**DEVELOPMENT CONTROL
Arun District Council
The Arun Civic Centre,
Maltravers Road,
Littlehampton,
West Sussex
BN17 5LF**

**Ian Ronald Lloyd
3, Elmer Court,
Elmer Sands,
Middleton-on-Sea,
West Sussex
PO22 6JT**

**PLANNING APPLICATION HOUSEHOLDER.....APPLICATION NO. M/62/17/HH...
Replace two storey extension & erection of rear balcony & external staircase
at 2, Elmer Court, Middleton-on-Sea**

Drawing No. 1645/2010D

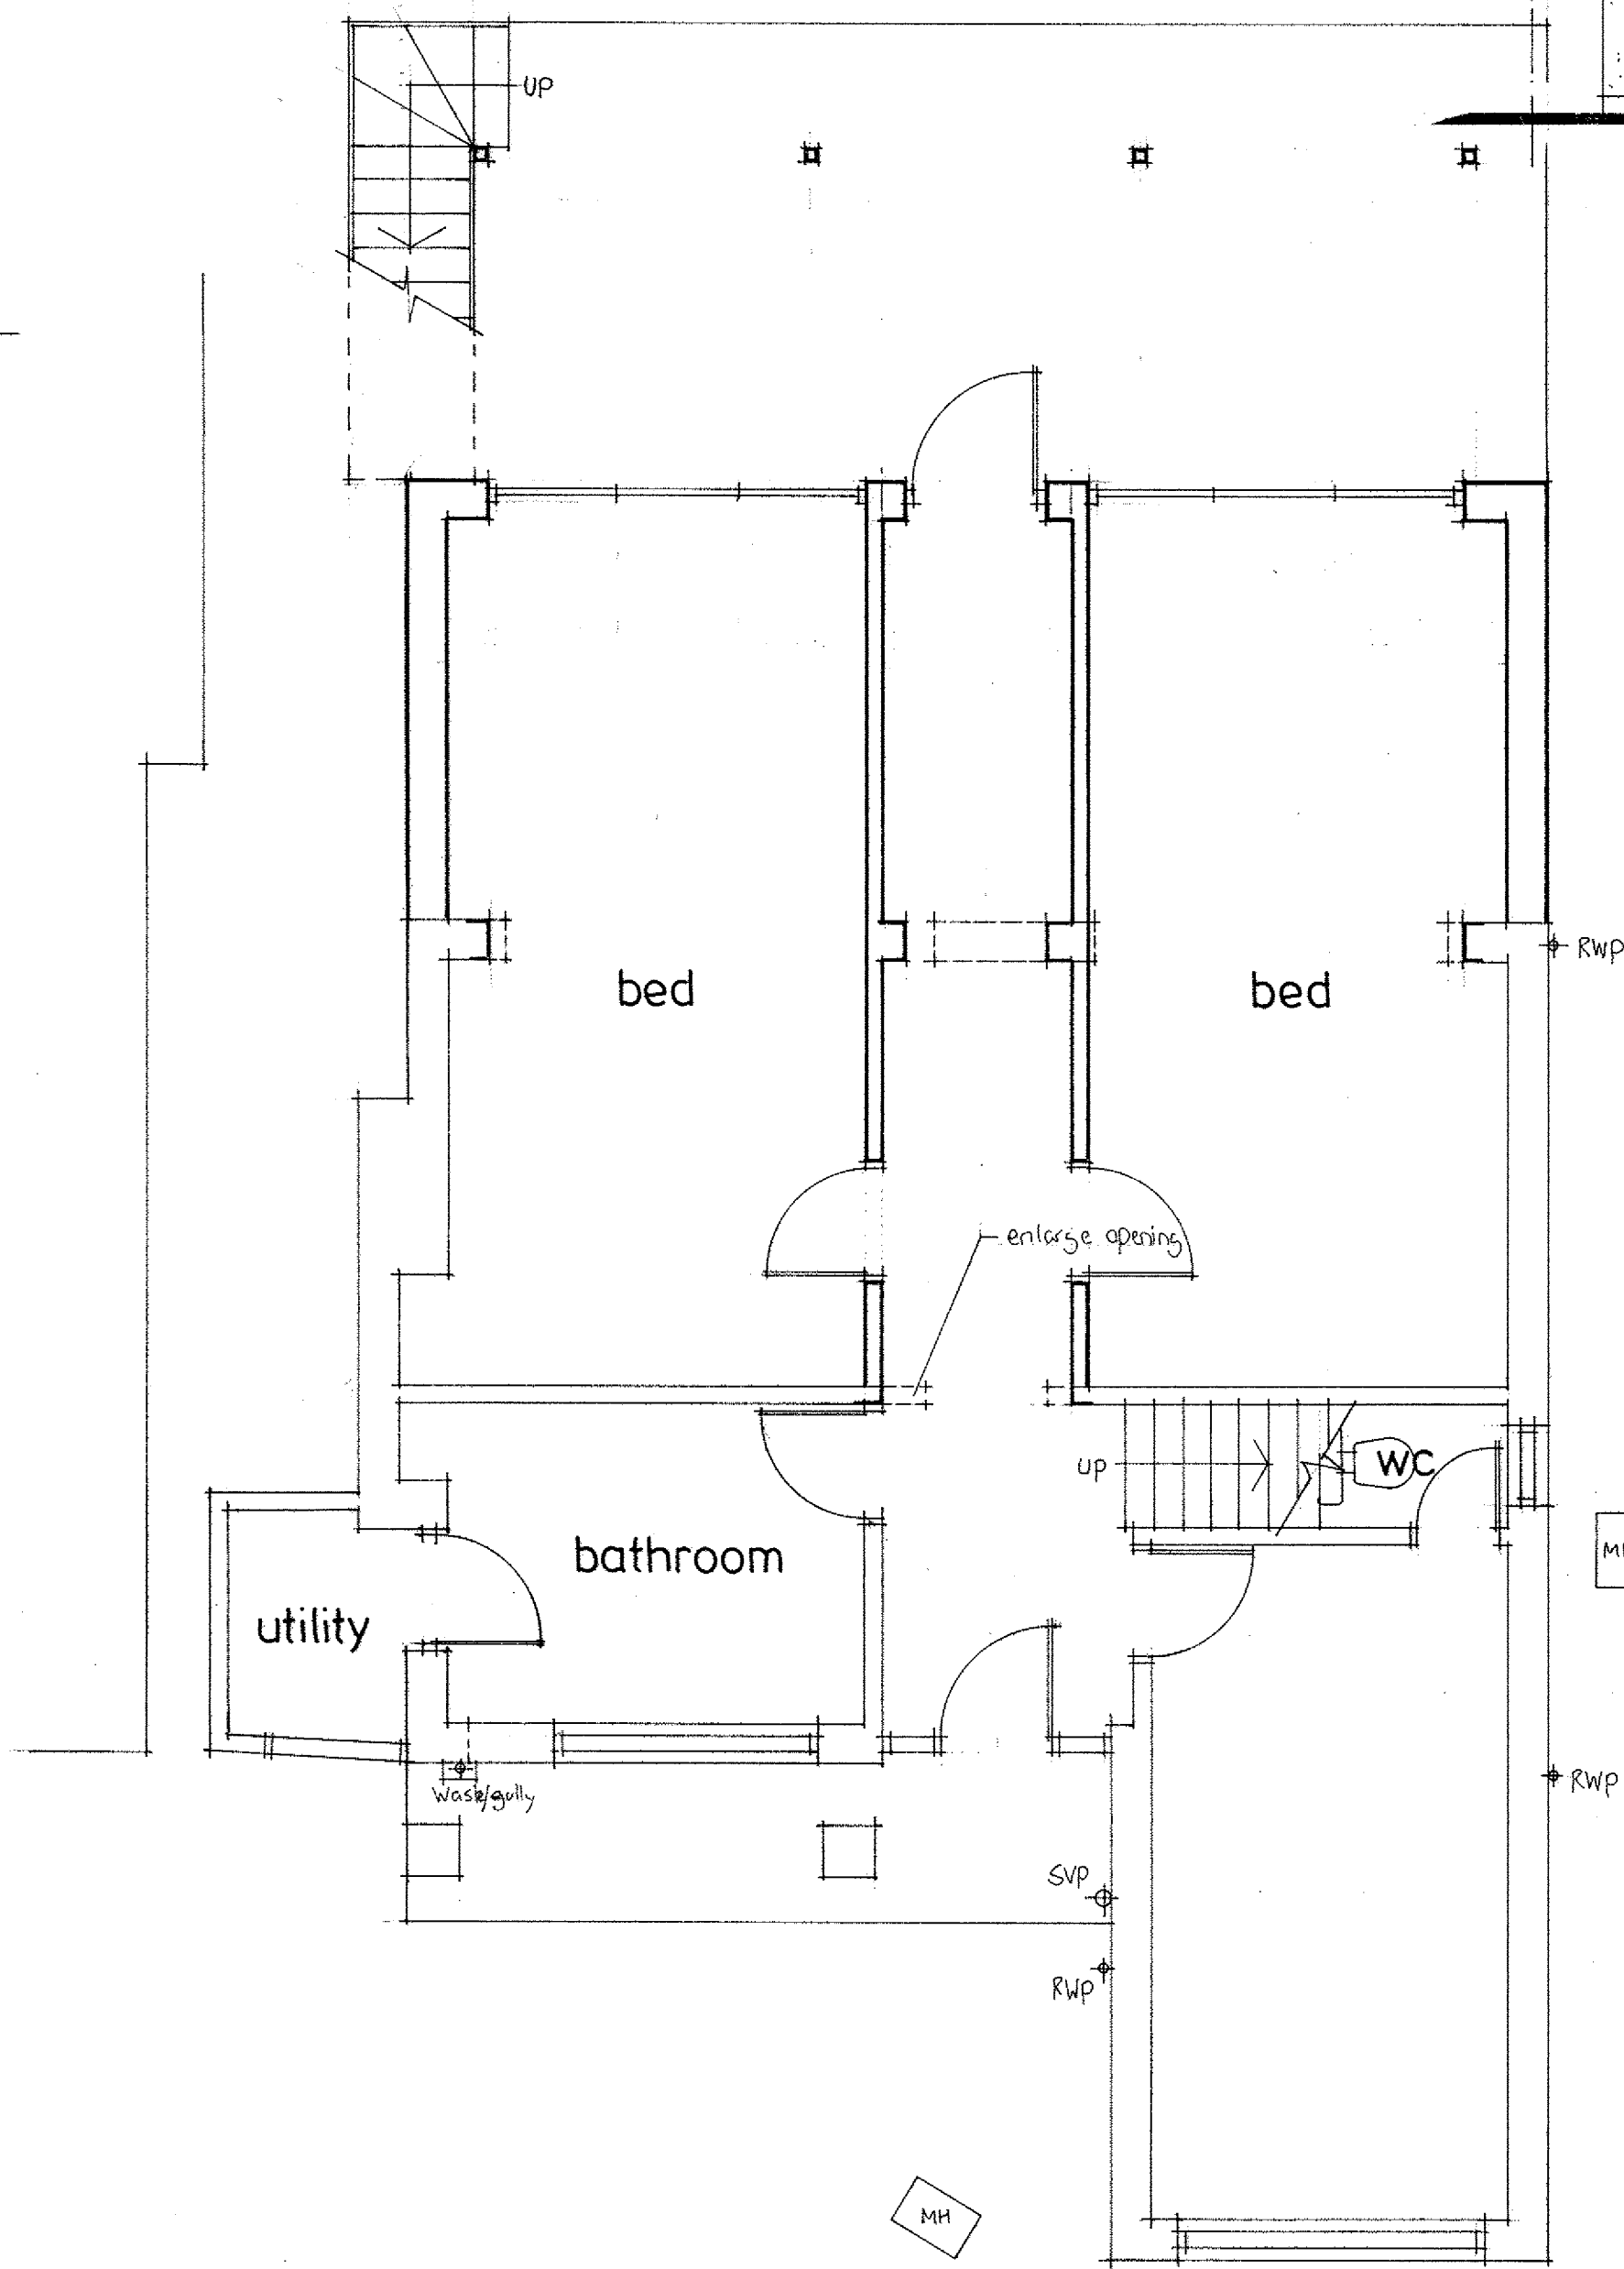
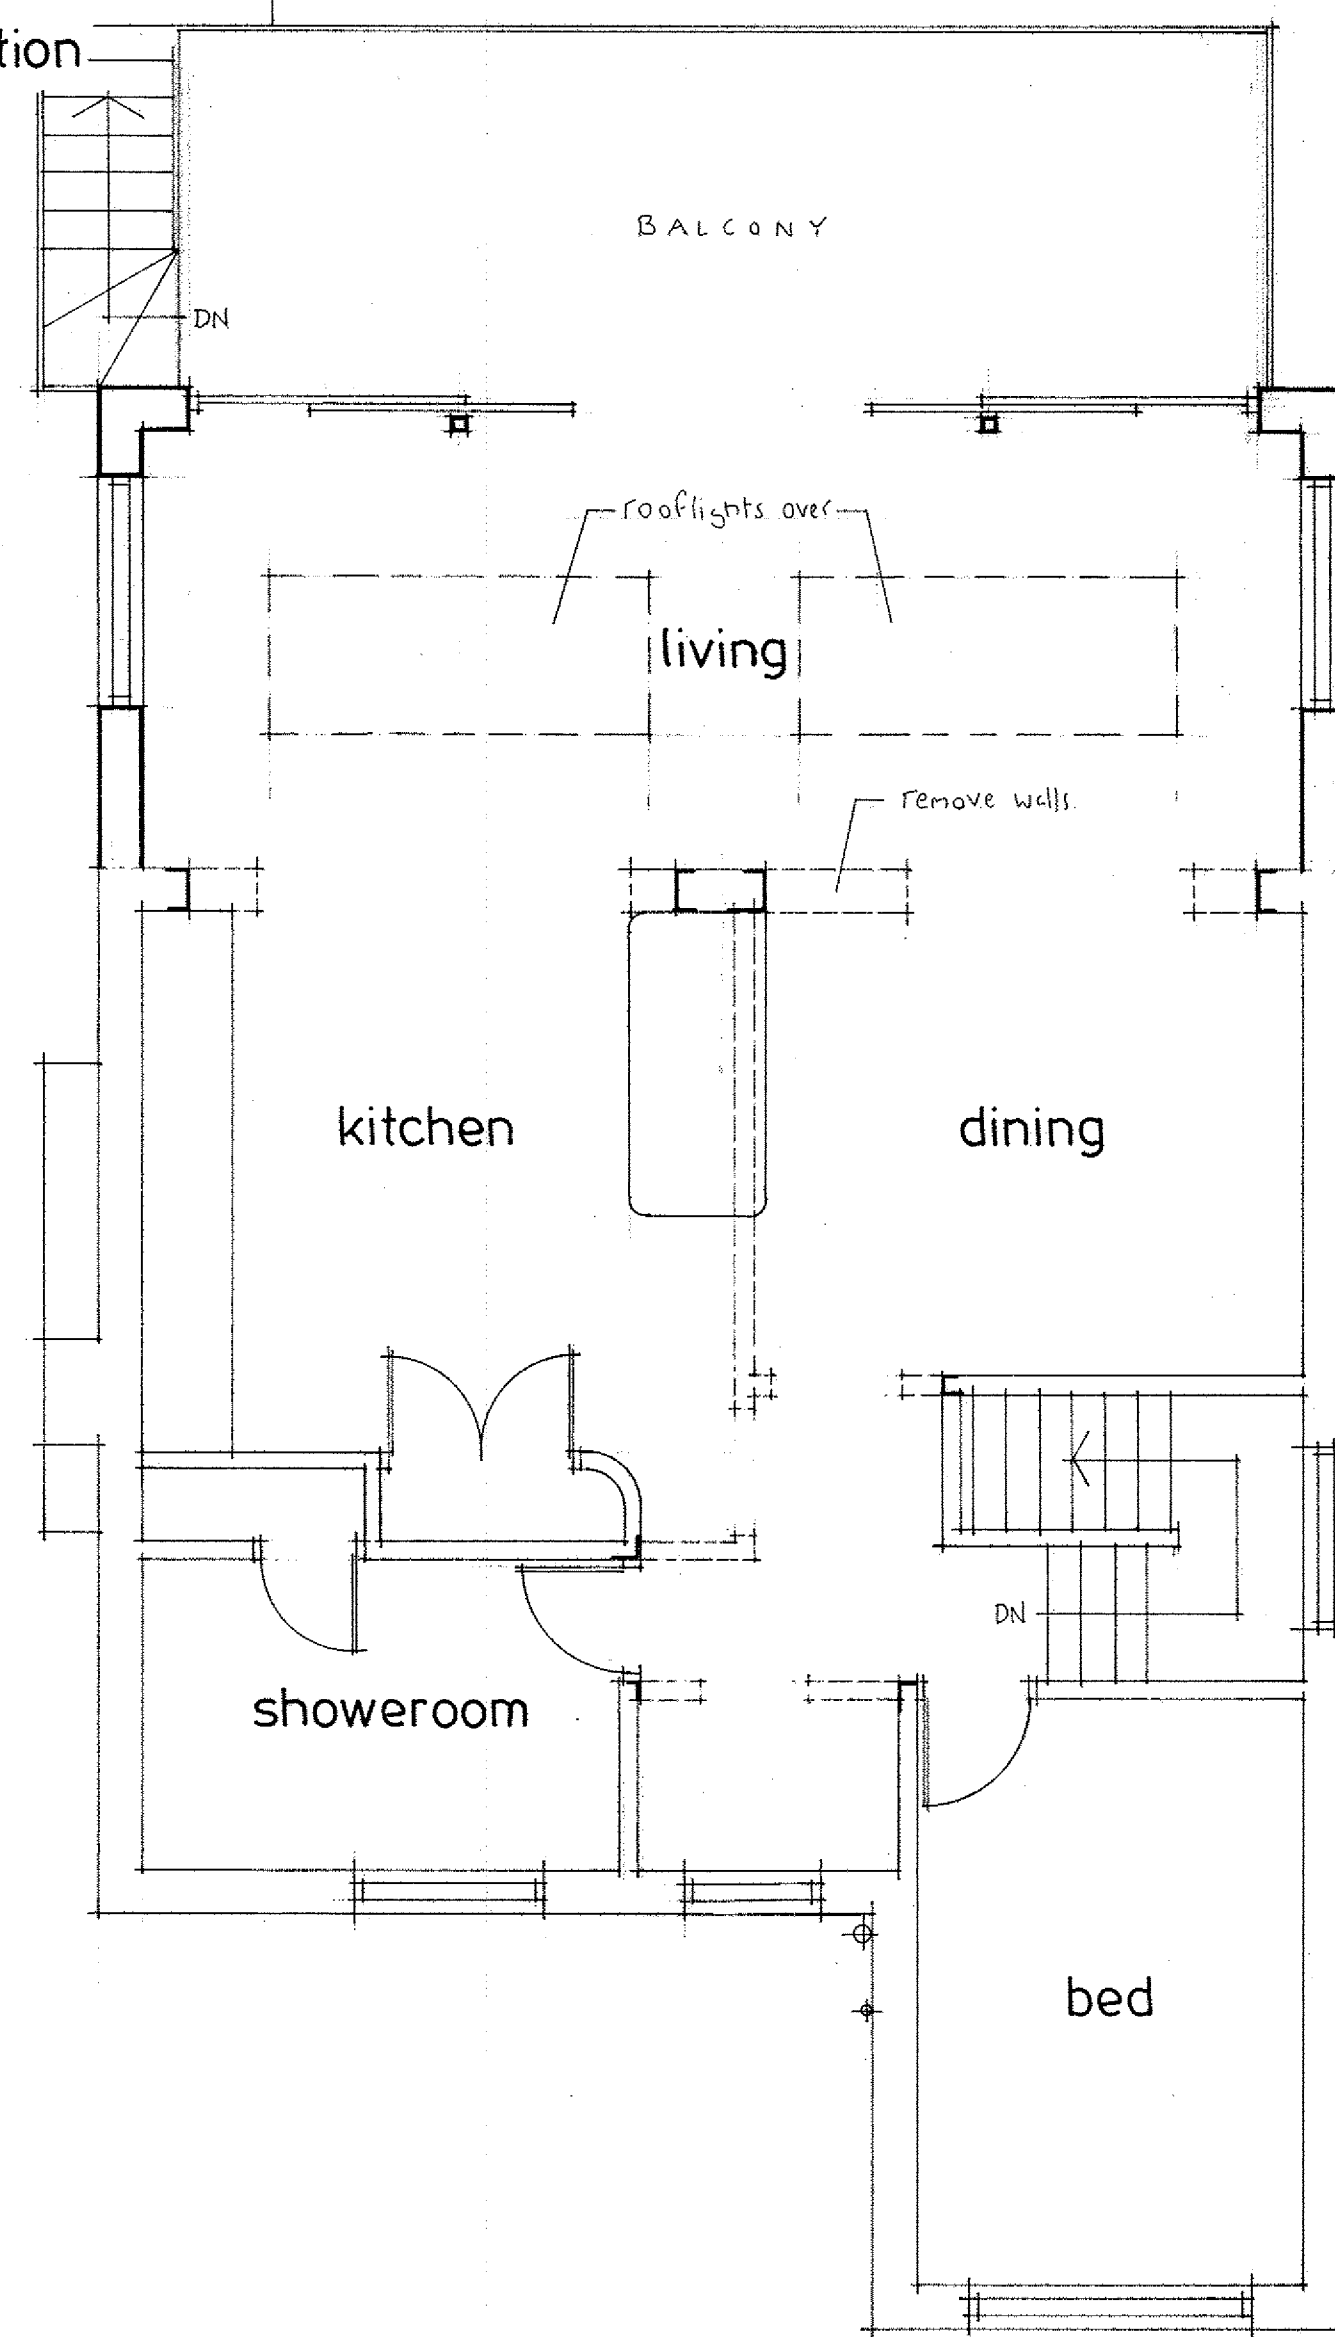
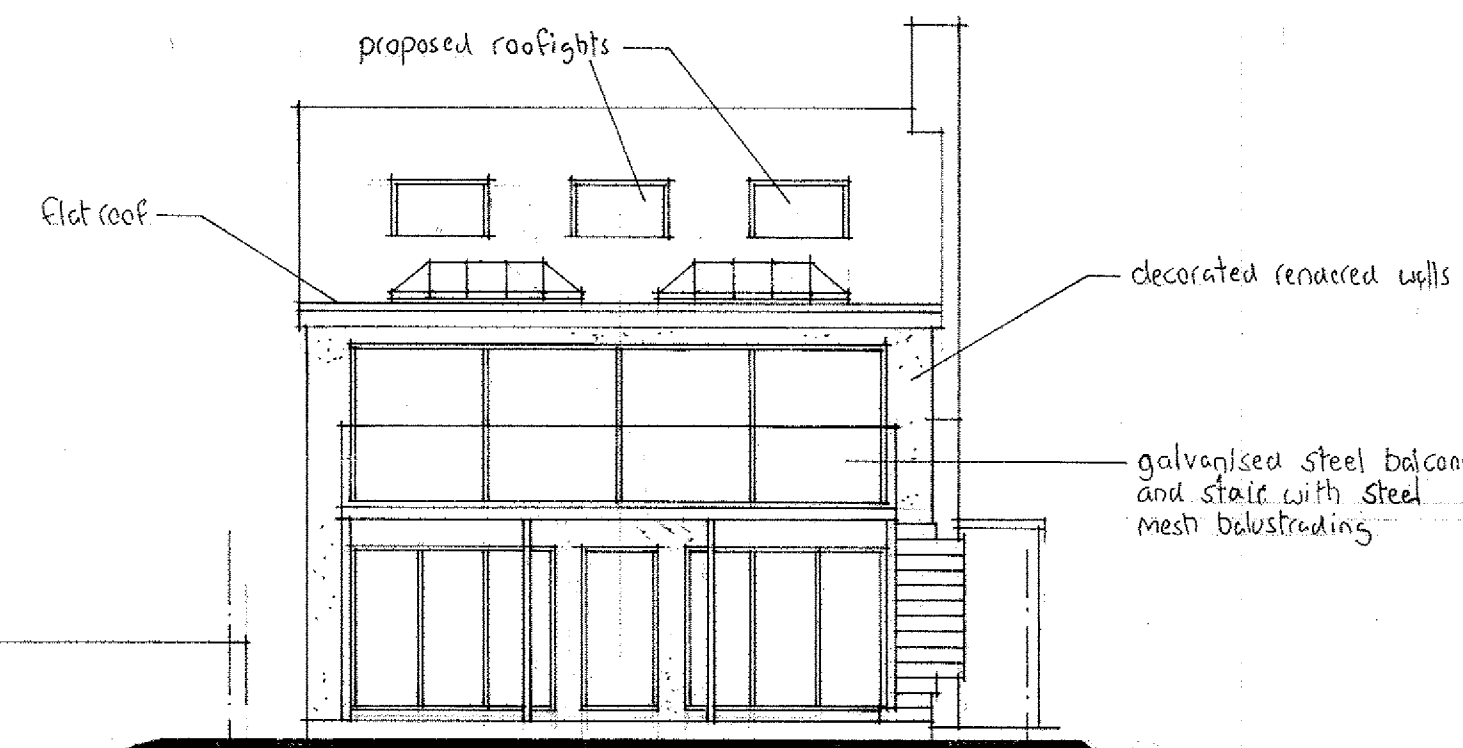
- (1) Effect on the daylight and privacy of my property..... Possibly, but only very slightly. The two storey extension is being rebuilt only slightly larger than existing. The proposed balcony extends only 2.4 metres (approx.) further south from the two storey extension.**
- (2) Design, appearance and layout.....I believe Planners look at the design and appearance of balustrades. I have no observations.**
- (3) Flood Risk..... The rainwater from the flat roof of the existing two storey structure discharges into a hopper and rainwaterpipe and then to a soakaway. I assume that will remain the same with the new structure although the rainwater pipe will need to be repositioned and alteration made to the connection below ground. In respect to the discharge of rainwater from the proposed balcony I assume a similar method will be provided.**
